Mr S Kripalani (client)  
Leeds 2 Properties Limited  
Dudley Surgical Appliances  
52 Horseley Road, Dudley Port  
Tipton, DY4 7AA  
19<sup>th</sup> April 2021

**Planning Reference: DC/20/63945**

Further to the submission of the non-material amendment (NMA) and subsequent email on 31<sup>st</sup> March to Sandwell planning.

Proposed First Floor

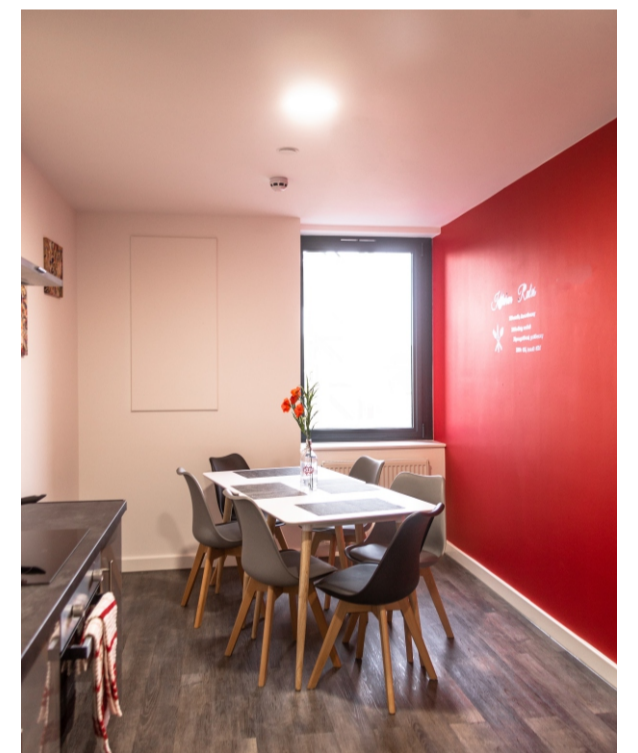
Small affordable accommodation is still required however they are requesting slight additions to the kitchenette area to include a small sink and maybe 2 ring hob. The accommodation would remain a shared HMO, with a shared kitchen. However, they have the choice of using their own small amenity rather than share during these times.

Therefore, the request for the non-material amendment is for the above as per submitted plans. The development is quality, affordable shared accommodation within Sandwell for which there is a demand.
